Lane Cove West Data Centre Application SSD-9741: Submission

SUMMARY

Drawing Title
VISUAL IMPACT SECTION

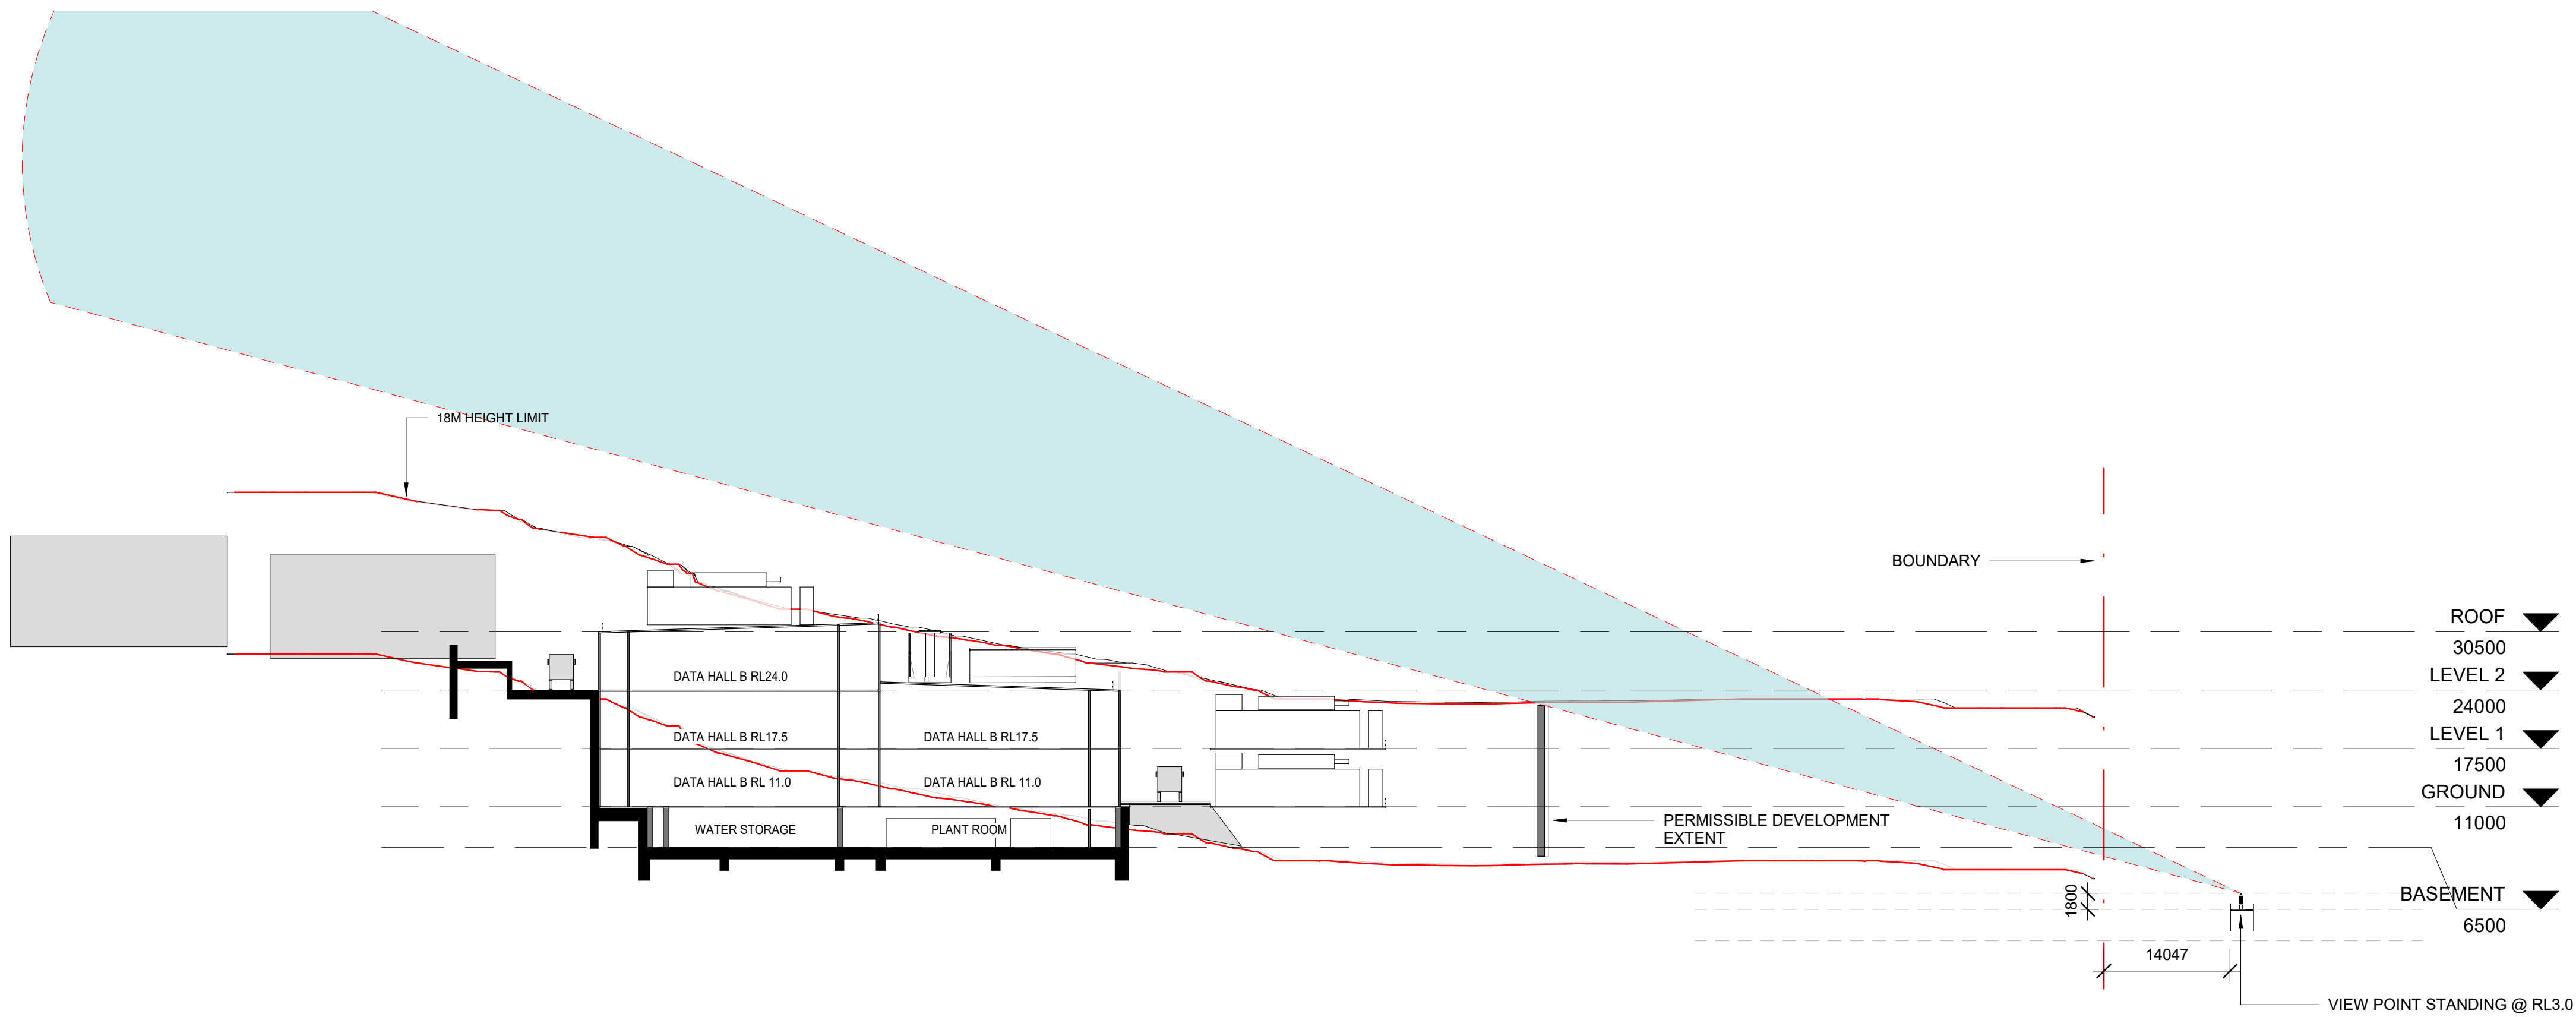
19. The maps used do not make clear just how much the building work intrudes into the below cliff natural habitat (however disturbed it might be by past activity). It is not just a corridor for the walking public, but part of a habitat strip representing pre-1788 natural forms and ecological associations, coexisting with suburban and industrial occupancy.
20. The proposal stretches the industrial zone beyond its intended purpose, thus triggering the need to work closely with landscape planners managing the public reserves, and state managers of the riverine environment. There is no evidence of this yet in the documents produced..
